**TRANSITIONAL PART 3A PROJECT
ASSESSMENT**

**Section 75W Modification Request
DEXUS Industrial Estate, Greystanes
Southern Employment Lands, Holroyd
Local Government Area
(MP08_0259 MOD 5)**

Director-General's
Environmental Assessment Report
Section 75W of the
Environmental Planning and Assessment Act 1979

May 2013

drawing title
Swept Paths - Ground Loading Docks 1 & 2

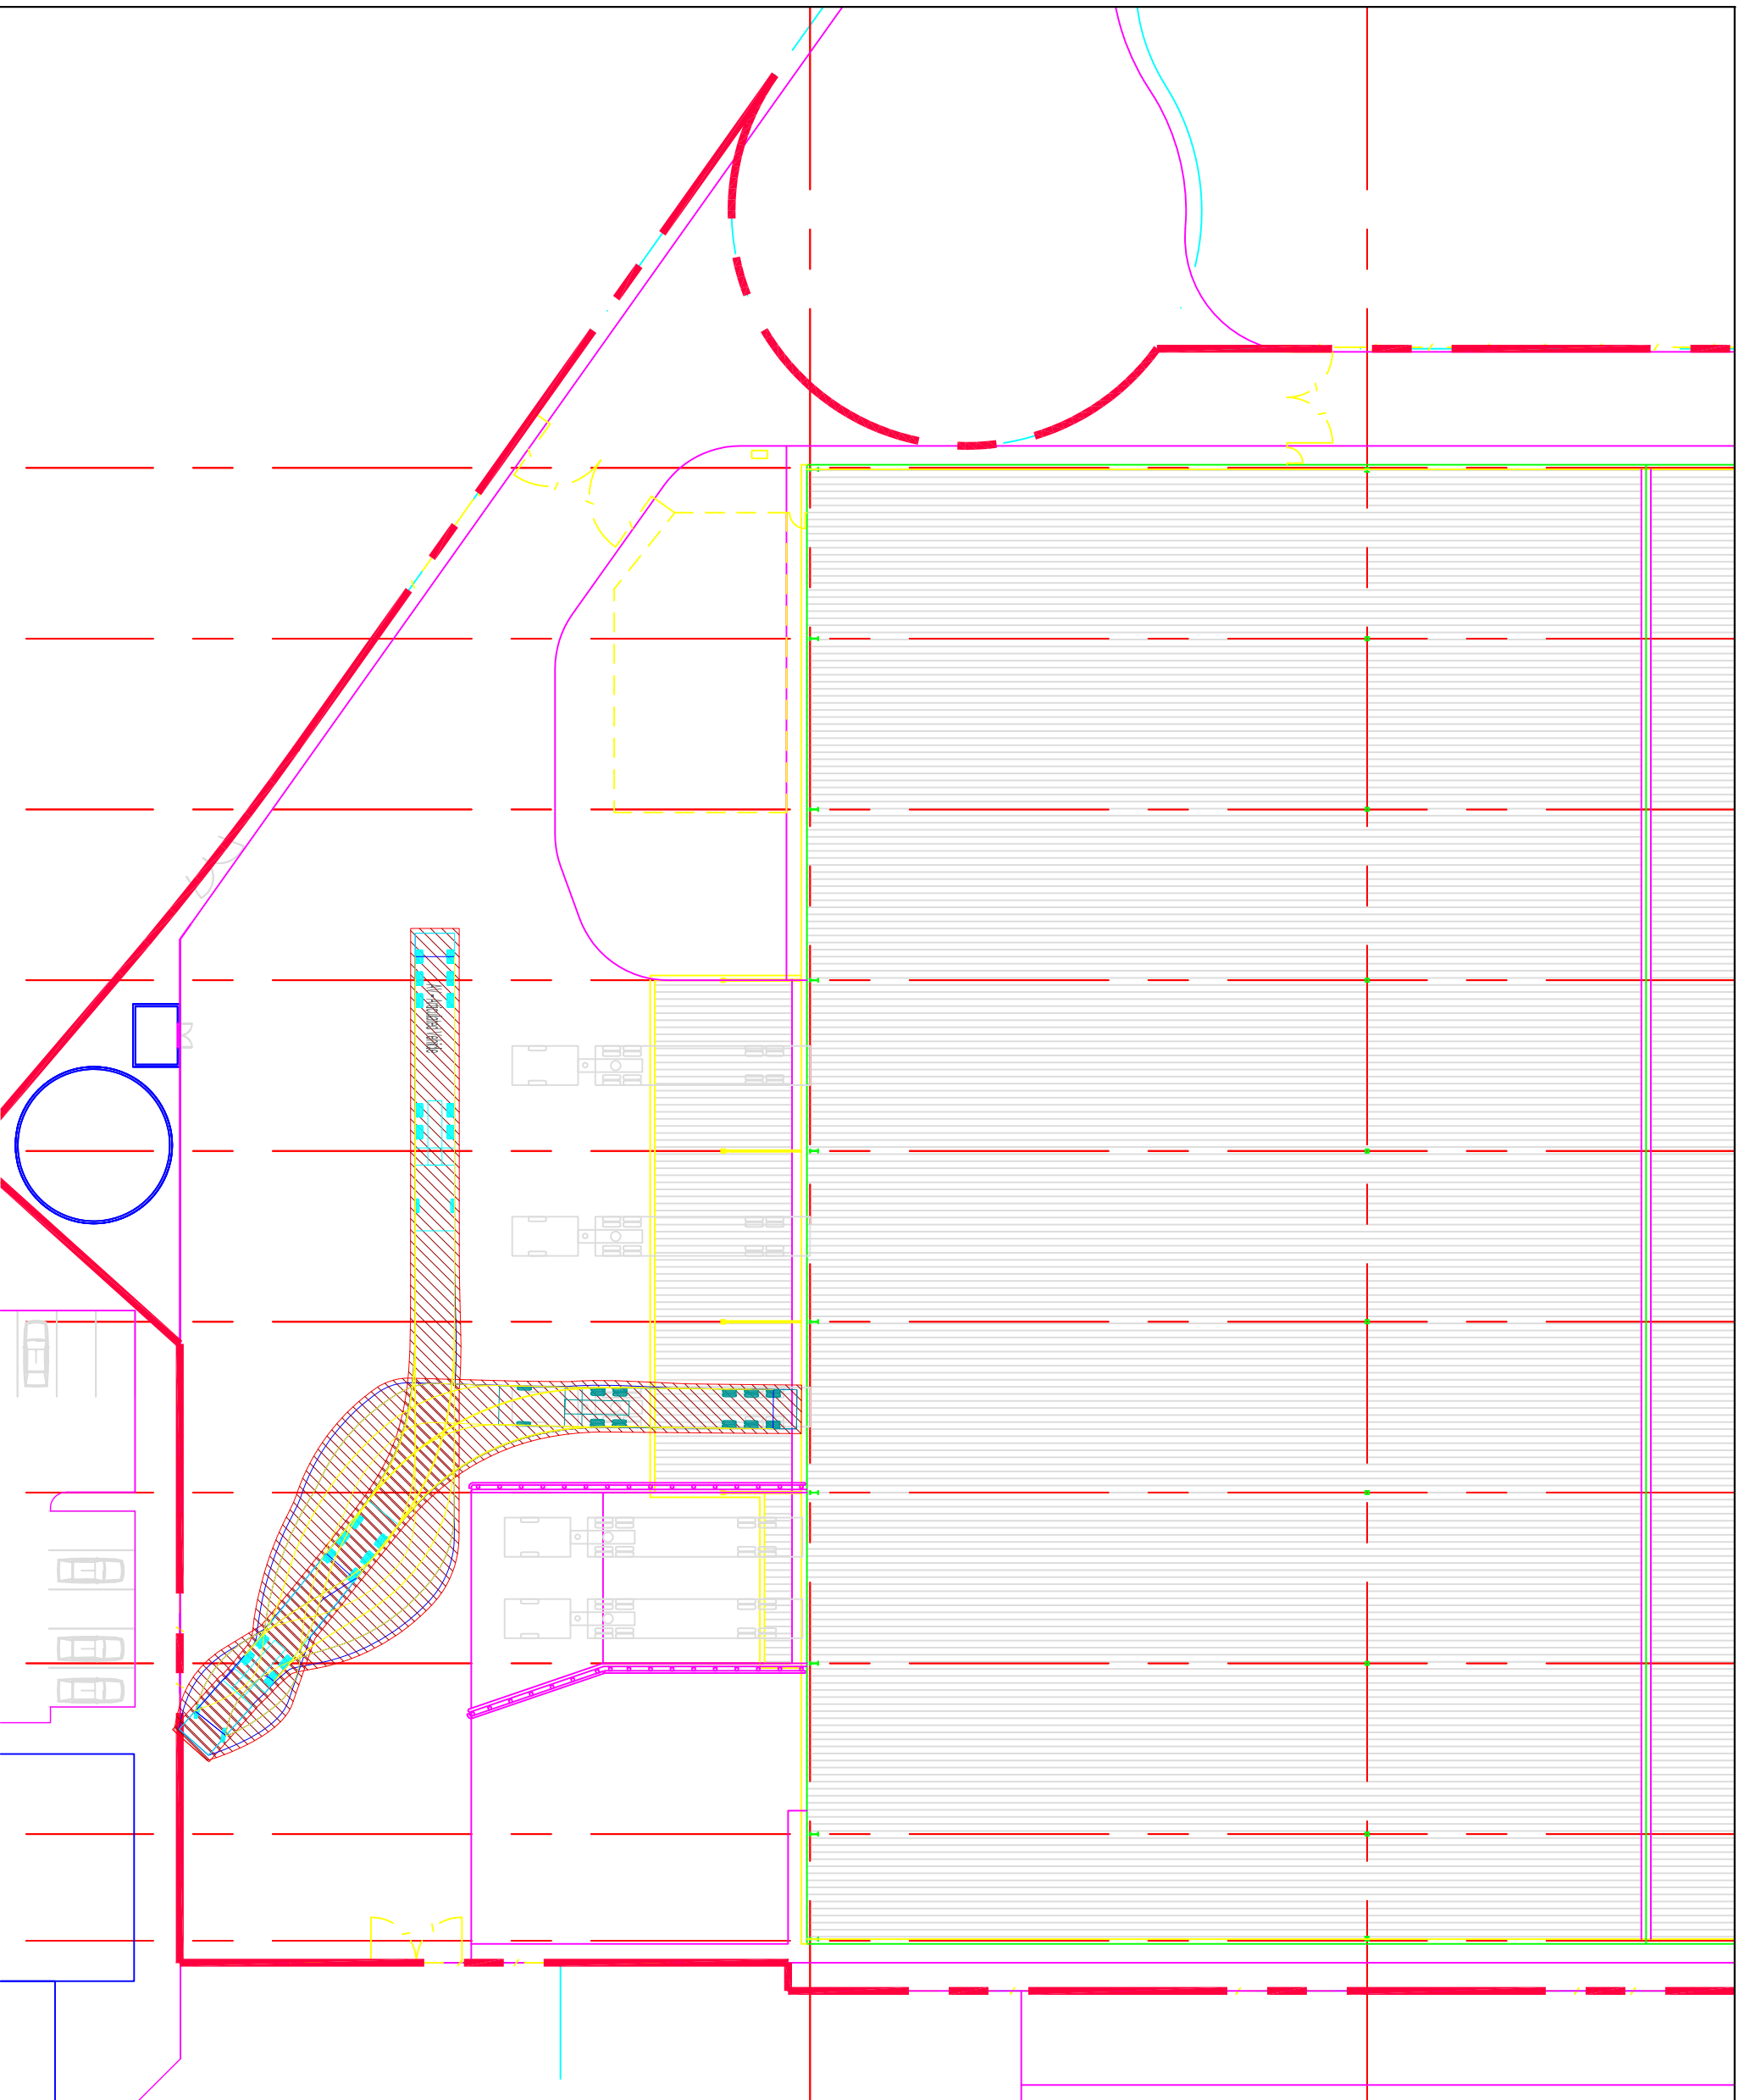
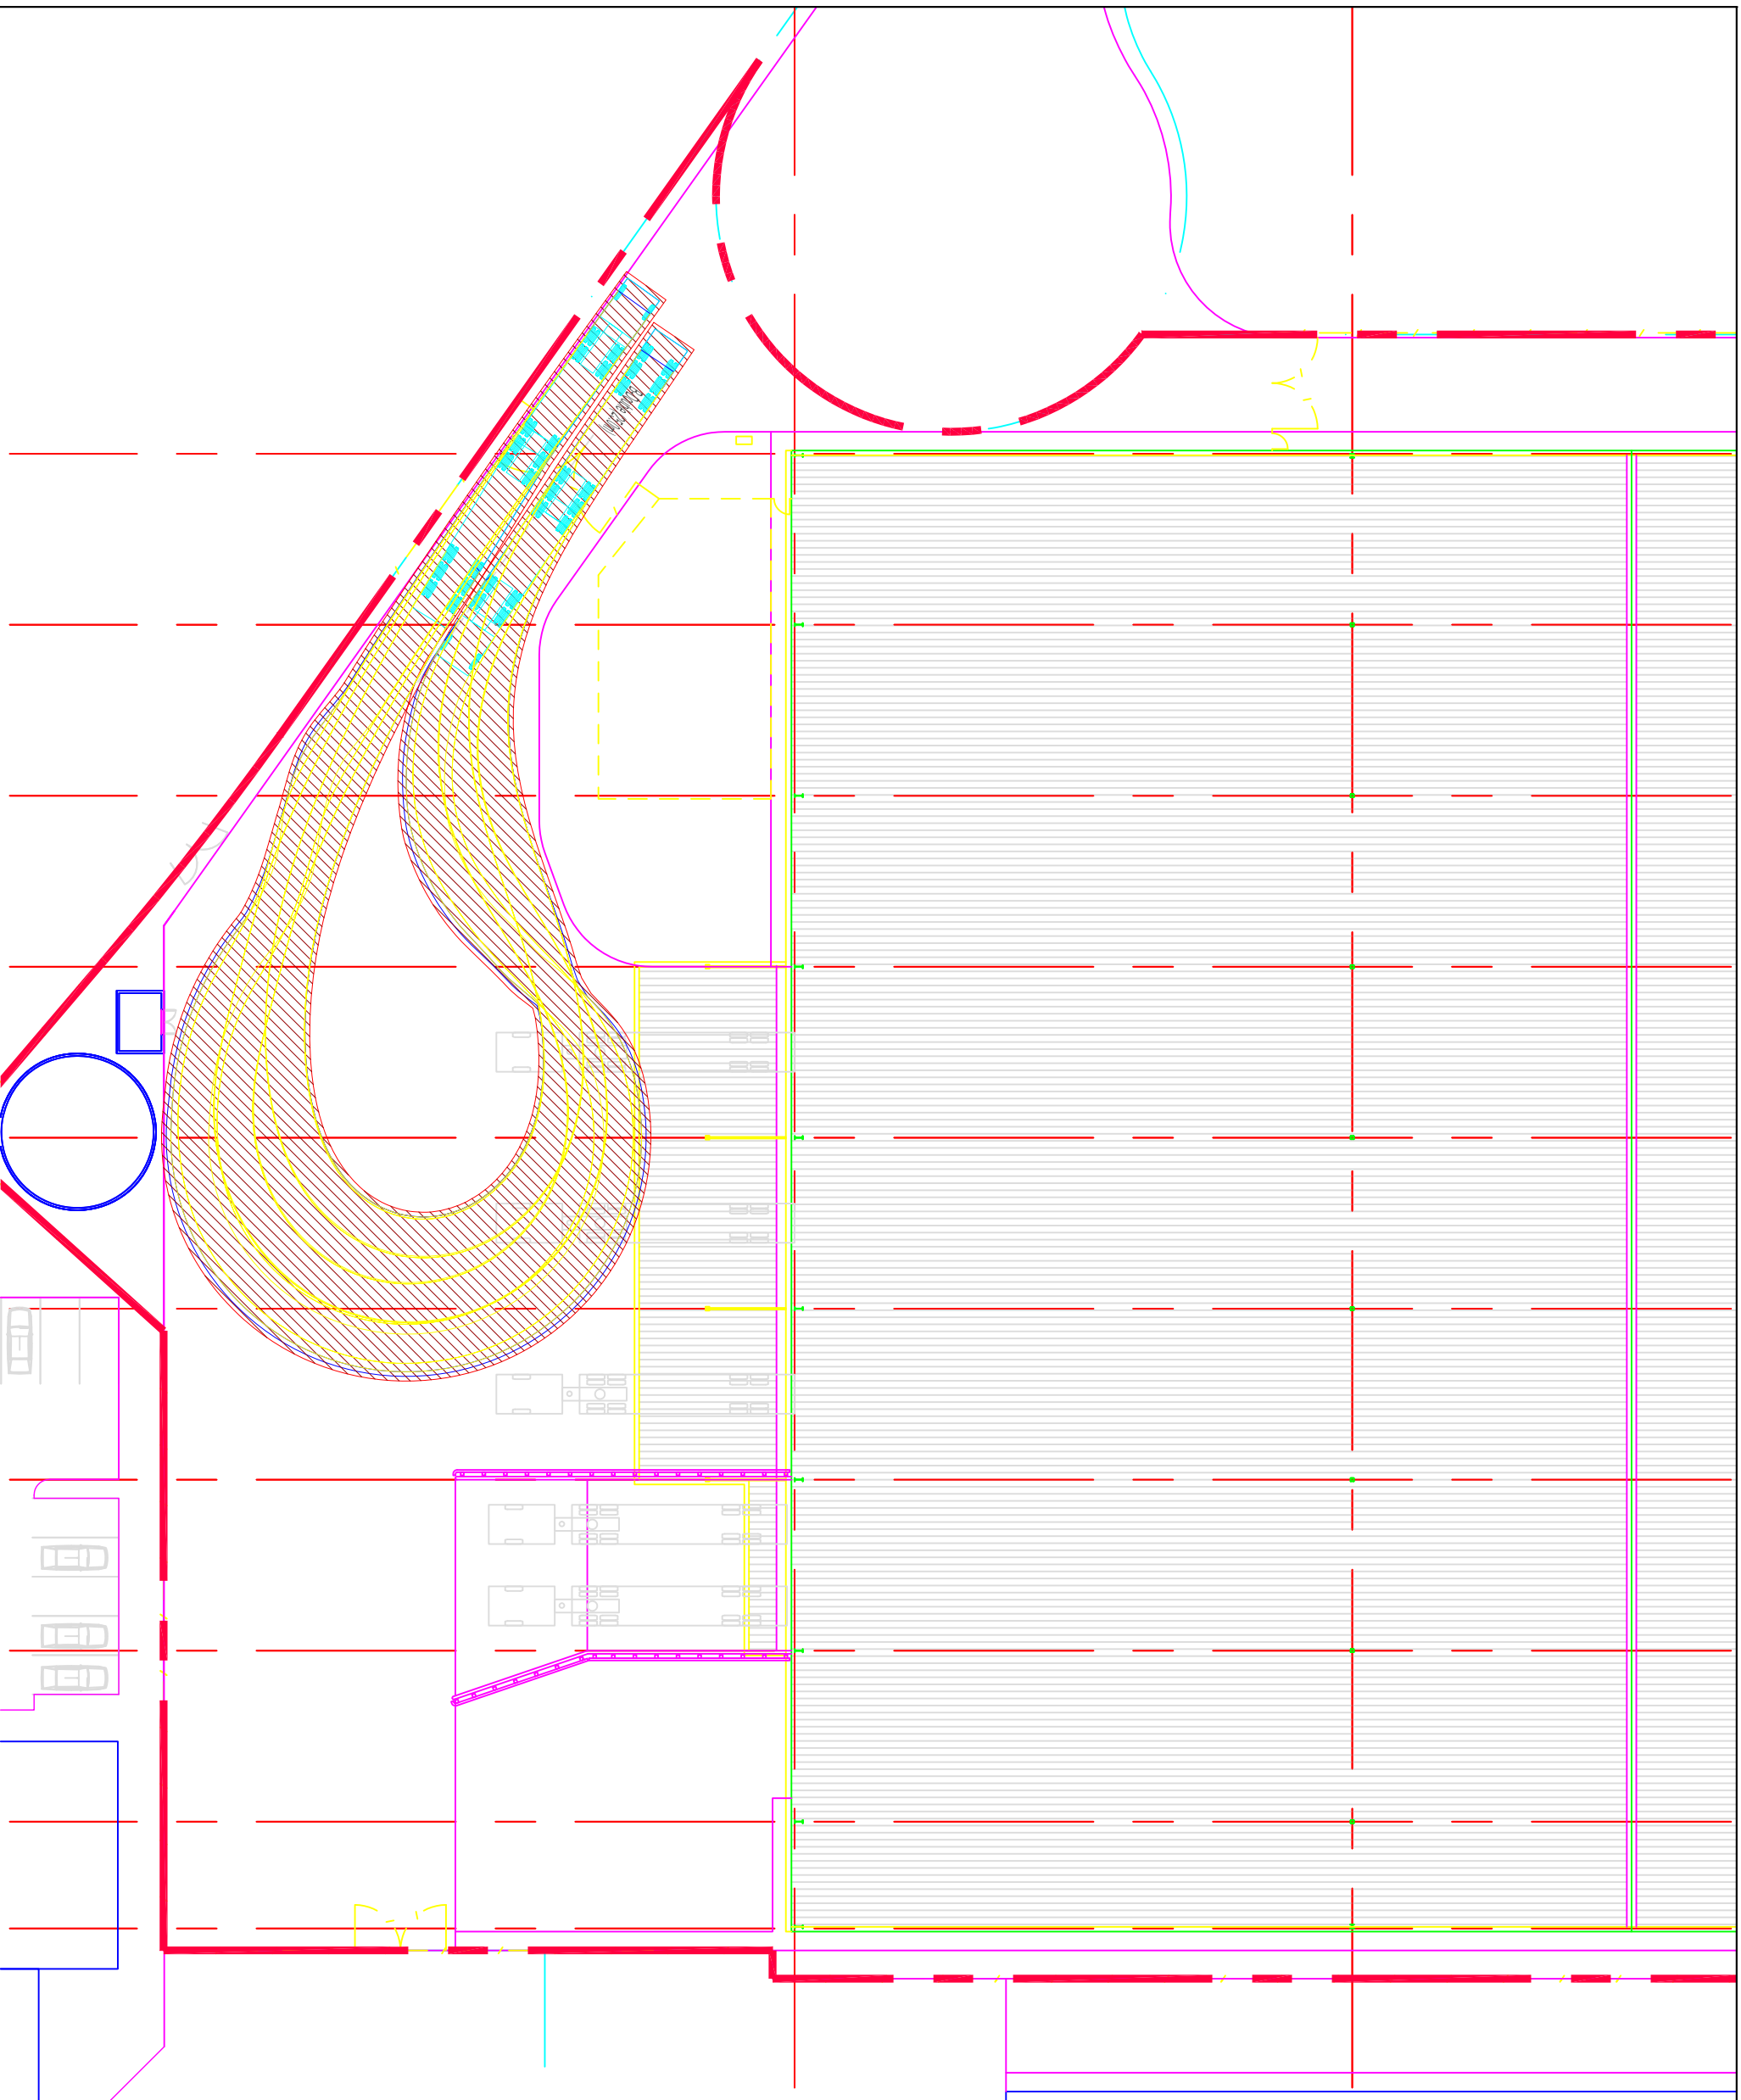
21. Swept paths	Swept paths are provided on the plans for the largest vehicle proposed to access the site (ie. 19 metre articulated, with adequate capacity for b-doubles to enter and exit in a forward direction).
